**MODIFICATION TO PROJECT APPLICATION MP 09_0184
COSTCO, 17-21 PARRAMATTA RD, LIDCOMBE**

On behalf of Costco Wholesale Australia Pty Ltd we write to request the Minister (or his delegate) modify the Project Approval MP 09_0184 under Section 75W of the *Environmental Planning and Assessment Act 1979* as described below.

The modifications relate to minor design changes to the development, including a reduction in height of the roof parapets, addition of new egress stairs, and minor revisions to the extent and positioning of some interior elements.

A3-3000-DA

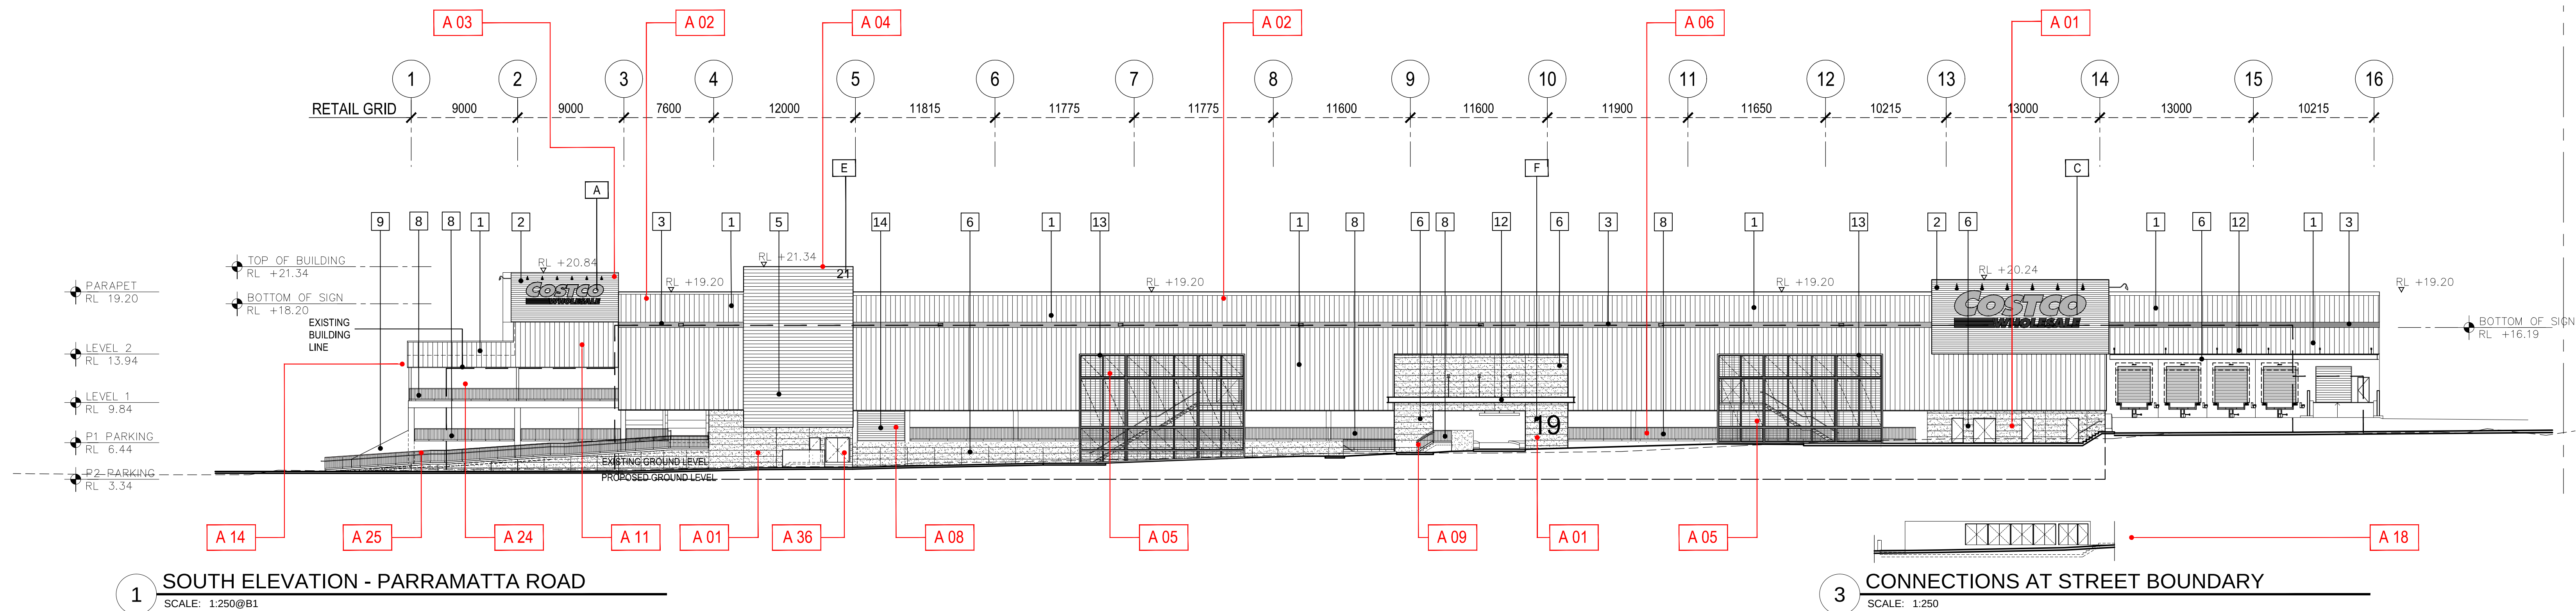
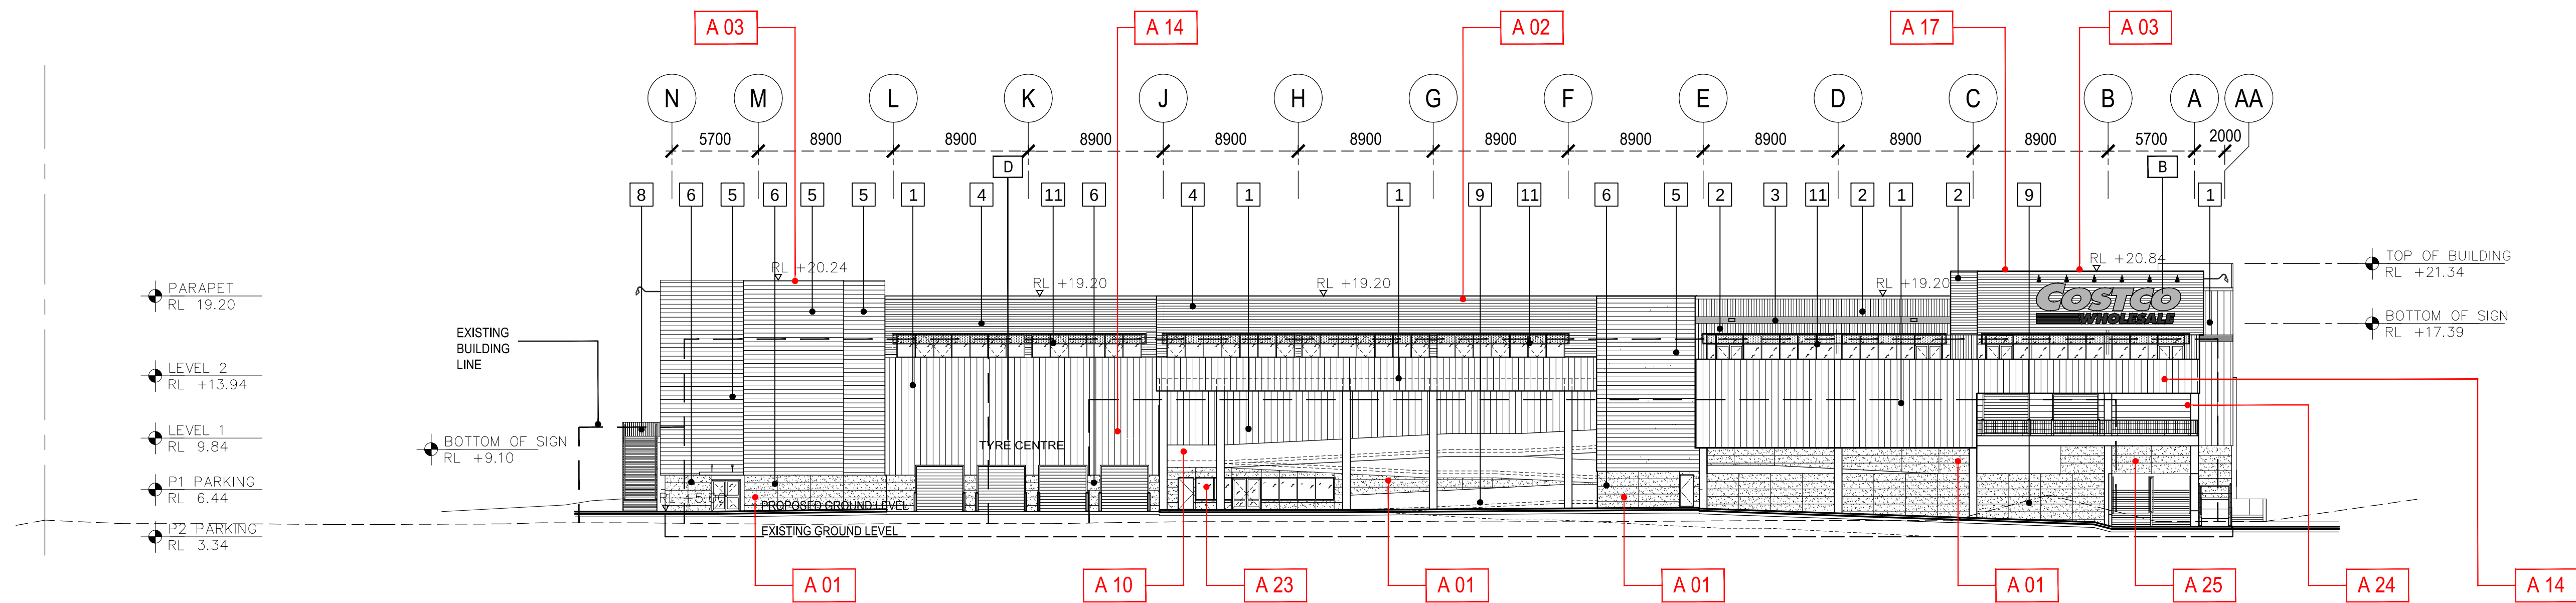
Level	Description of Proposed Modification	Annotation No. on plan
Elevation (A3-3000-DA)	<ul style="list-style-type: none"> Amendments to entry into the forecourt, including provision of ramp from ground floor level 	<ul style="list-style-type: none"> A 25
	<ul style="list-style-type: none"> Removal of glazing at mezzanine level and metal cladding extended 	<ul style="list-style-type: none"> A 11
	<ul style="list-style-type: none"> Addition of roller blind assemblies to the external food court in the western corner for sun shading and weather protection 	<ul style="list-style-type: none"> A 24
	<ul style="list-style-type: none"> Top of parapet reduced from RL 21.84 to RL 20.84 	<ul style="list-style-type: none"> A 03
	<ul style="list-style-type: none"> Main roof parapet reduced from RL 19.70 to RL 19.20 	<ul style="list-style-type: none"> A 02
	<ul style="list-style-type: none"> Textured precast concrete to replace block wall finish 	<ul style="list-style-type: none"> A 01

<ul style="list-style-type: none"> Reduction of stair parapet from RL 21.84 to RL 21.34 	<ul style="list-style-type: none"> A 04
	<ul style="list-style-type: none"> Addition of louvers to facade 	<ul style="list-style-type: none"> A 08
	<ul style="list-style-type: none"> Stair enclosures amended to metal screens 	<ul style="list-style-type: none"> A 05
	<ul style="list-style-type: none"> Addition of stair egress 	<ul style="list-style-type: none"> A 09
	<ul style="list-style-type: none"> Metal mesh changed to metal balustrade 	<ul style="list-style-type: none"> A 06
	<ul style="list-style-type: none"> Amendment to positioning of Costco sign adjacent to loading dock area 	-
	<ul style="list-style-type: none"> Provision of water meter, gas meter with access doors opening into the site and fire facilities, with access doors onto Parramatta Road 	<ul style="list-style-type: none"> A 18
	<ul style="list-style-type: none"> Reconfiguration of egress stairs 	<ul style="list-style-type: none"> A 36

Western Elevation (A3-3000-DA)	<ul style="list-style-type: none"> Textured precast concrete to replace block wall finish 	<ul style="list-style-type: none"> A 01
	<ul style="list-style-type: none"> Top of parapet reduced from RL 21.84 to RL 20.84 	<ul style="list-style-type: none"> A 03
	<ul style="list-style-type: none"> Removal of canopy over food court and tyre centre 	<ul style="list-style-type: none"> A 14
	<ul style="list-style-type: none"> Repositioning of pedestrian ramp within the forecourt lobby area 	<ul style="list-style-type: none"> A 10
	<ul style="list-style-type: none"> Amendments to shop front glazing 	<ul style="list-style-type: none"> A 23
	<ul style="list-style-type: none"> Main roof parapet reduced from RL 19.70 to RL 19.20 	<ul style="list-style-type: none"> A 02
	<ul style="list-style-type: none"> Extent of metal cladding over the food court area increased 	-
	<ul style="list-style-type: none"> Increase in extent of metal wall cladding surrounding Costco sign in western corner 	<ul style="list-style-type: none"> A 17

<ul style="list-style-type: none"> Amendments to entry into the forecourt, including provision of ramp from ground floor level 	<ul style="list-style-type: none"> A 25
Northern Elevation (A3-3001-DA)	<ul style="list-style-type: none"> Addition of roller blind assemblies to the external food court in the western corner for sun shading and weather protection 	<ul style="list-style-type: none"> A 24
	<ul style="list-style-type: none"> Main roof parapet reduced from RL 19.70 to RL 19.20 	<ul style="list-style-type: none"> A 02
	<ul style="list-style-type: none"> Textured precast concrete to replace block wall finish 	<ul style="list-style-type: none"> A 01
	<ul style="list-style-type: none"> Addition of canopy over compactor area 	<ul style="list-style-type: none"> A 22
	<ul style="list-style-type: none"> Provision of one rainwater tank instead of two separate tanks 	<ul style="list-style-type: none"> A12

1 NORTH ELEVATION
SCALE: 1:250@B1

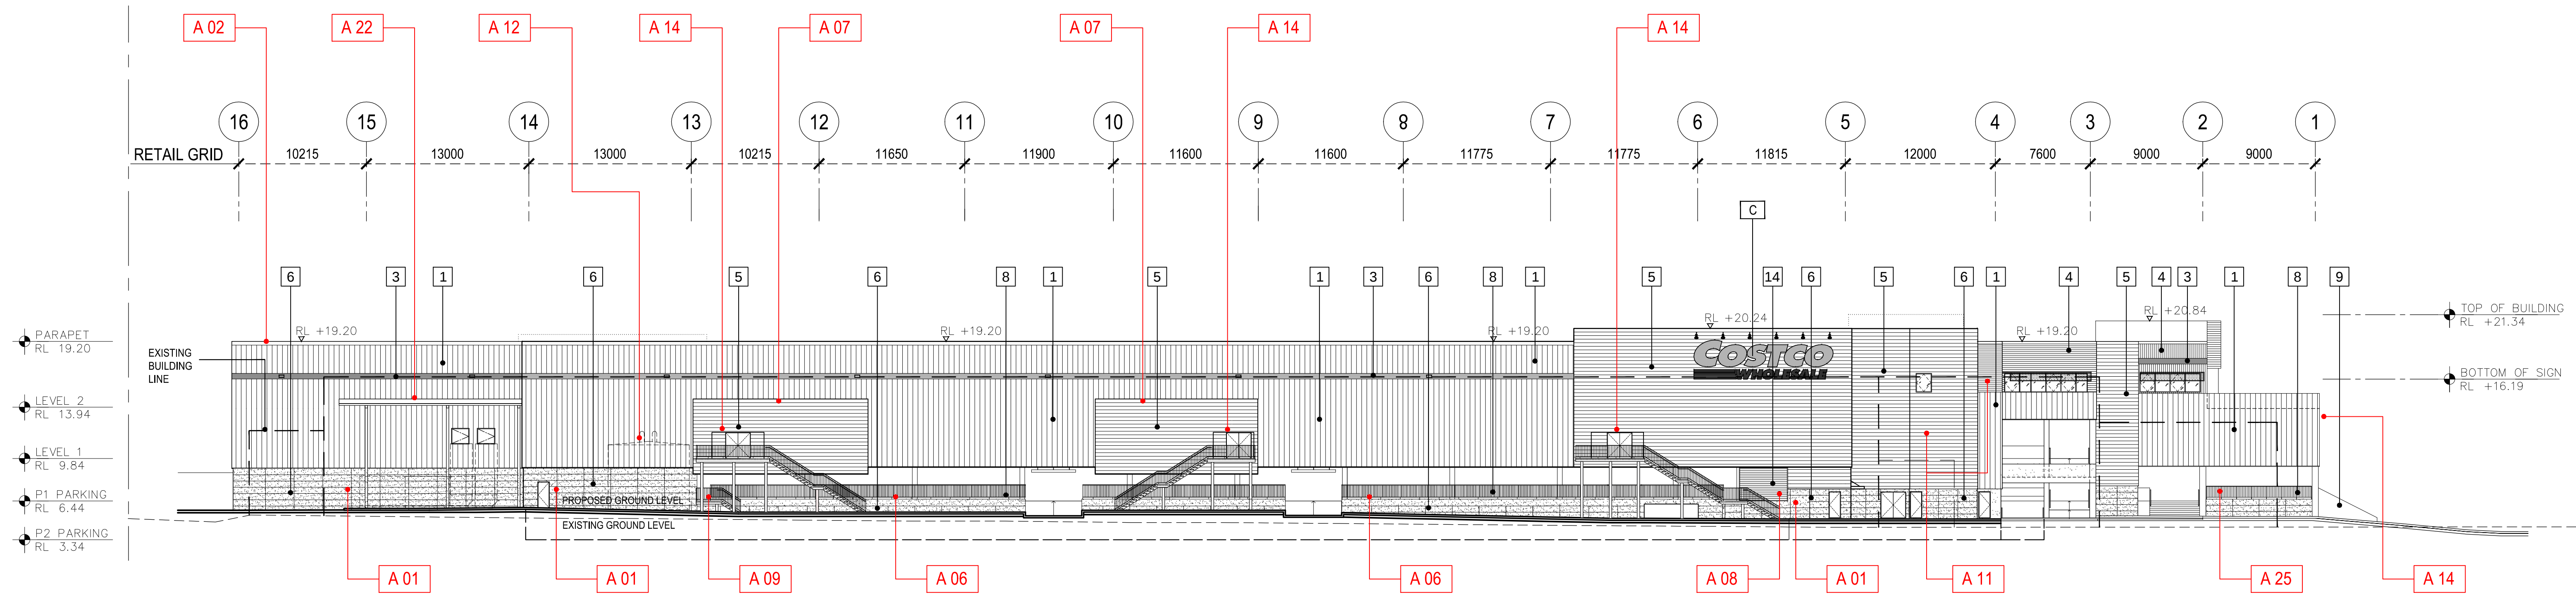
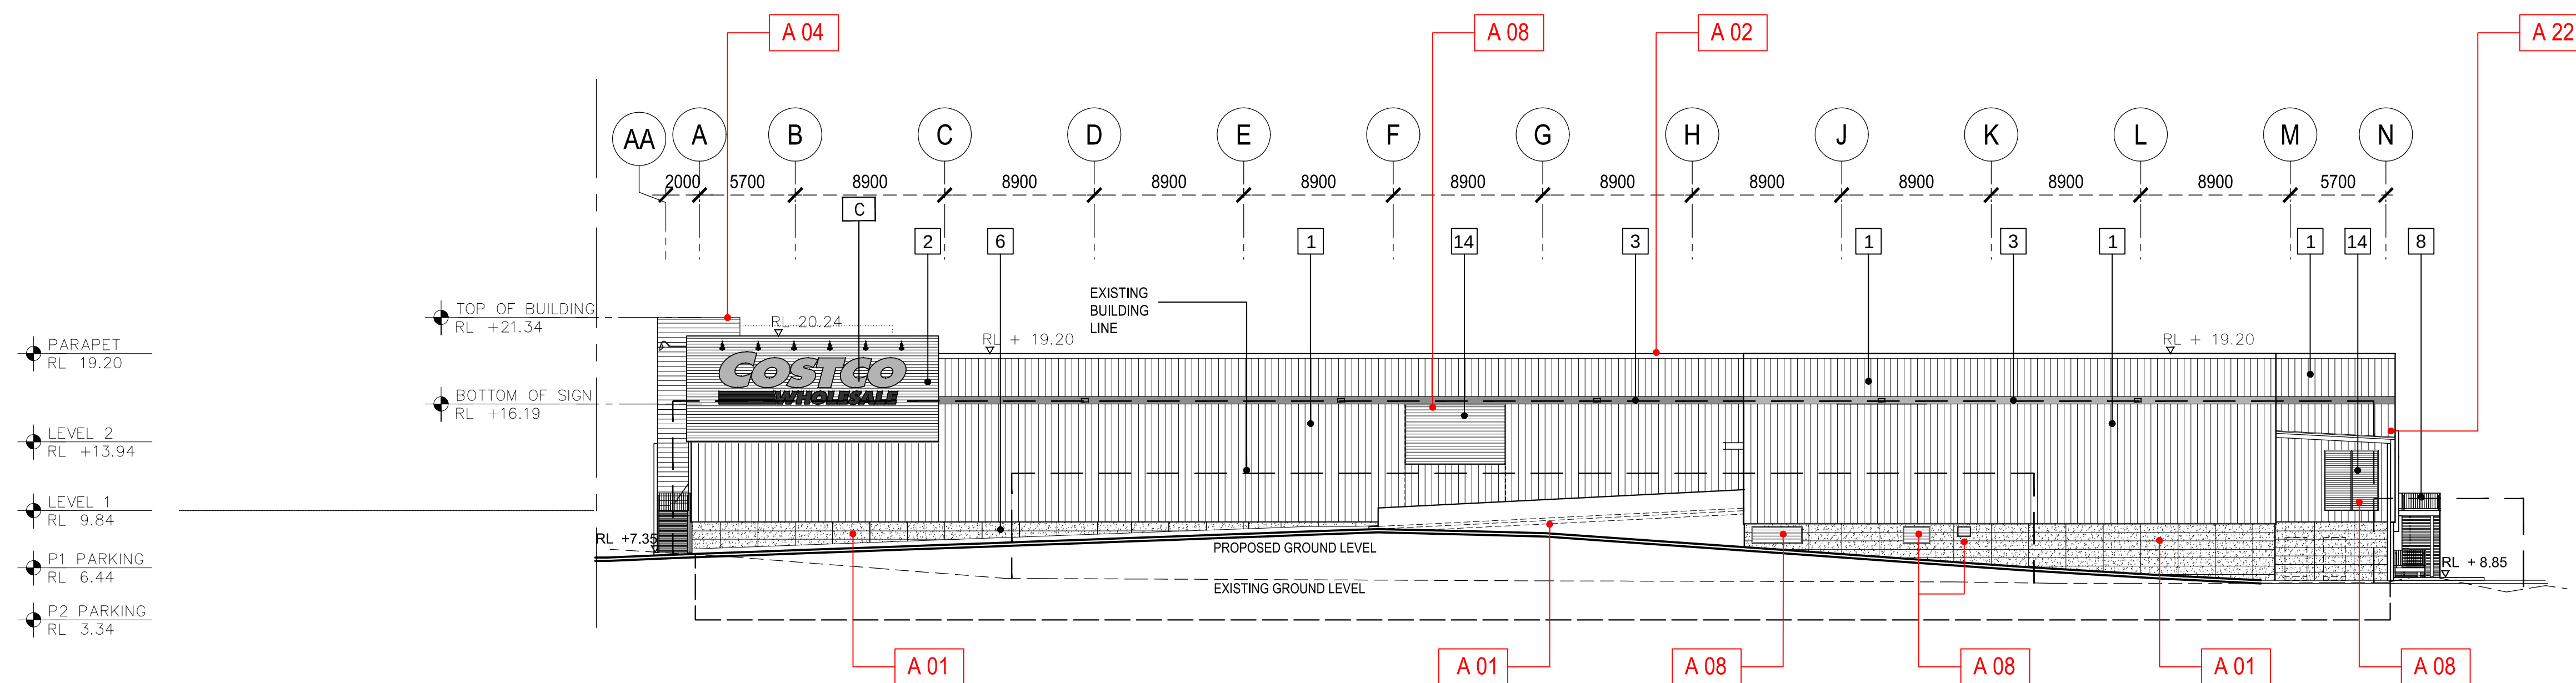
<ul style="list-style-type: none"> Addition of egress stairs 	<ul style="list-style-type: none"> A 09
	<ul style="list-style-type: none"> Reduction in the extent of the metal wall cladding 	<ul style="list-style-type: none"> A 07
	<ul style="list-style-type: none"> Metal mesh changed to metal balustrade 	<ul style="list-style-type: none"> A 06
	<ul style="list-style-type: none"> Addition of louvers to facade 	<ul style="list-style-type: none"> A 08
	<ul style="list-style-type: none"> Removal of windows from at mezzanine level and level 1 	<ul style="list-style-type: none"> A 11
	<ul style="list-style-type: none"> Amendments to entry forecourt area 	<ul style="list-style-type: none"> A 25

Level	Description of Proposed Modification	Annotation No. on plan
	<ul style="list-style-type: none"> Removal of canopy over food court and canopies over the stair egress doorways 	<ul style="list-style-type: none"> A 14
Eastern Elevation (A3-3001-DA)	Reduction of stair parapet from RL 21.84 to RL 21.34	A 04
	Textured precast concrete to replace block wall finish	A 01
	Addition of louvers to facade	A 08
	Main roof parapet reduced from RL 19.70 to RL 19.20	A 02
	Addition of canopy over compactor area	A 22
